Sent: 01 April 2011 08:27
To: Planning
Subject: Comments Added: Former Shredded Wheat Factory, Broadwater Road West, Welwyn Garden City

Application ID: N6/2010/2055/MA - Mr R Aston Application Owner: Welwyn & Hatfield Borough Council(Development Control Officer)
Applicant: DP9
Location: Former Shredded Wheat Factory, Broadwater Road West, Welwyn Garden City Deadline Date: 16/03/2011 00:00:00
Description: Revised EIA Documents
Comment Added:

TOWN AND COUNTRY PLANNING ACT 1990
TOWN AND COUNTRY PLANNING (APPLICATION) REGULATIONS 1988 The Former Shredded Wheat Factory. WGC

Vehicular access

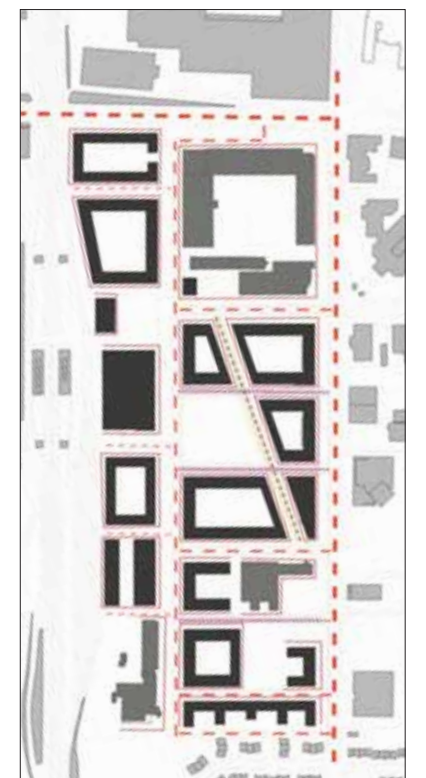
1. Access for fire fighting vehicles should be in accordance with The Building Regulations 2000 Approved Document B (ADB), section B5 sub-section 16.
2. Access routes for Hertfordshire Fire and Rescue Service vehicles should achieve a minimum carrying capacity of 20 tonnes.
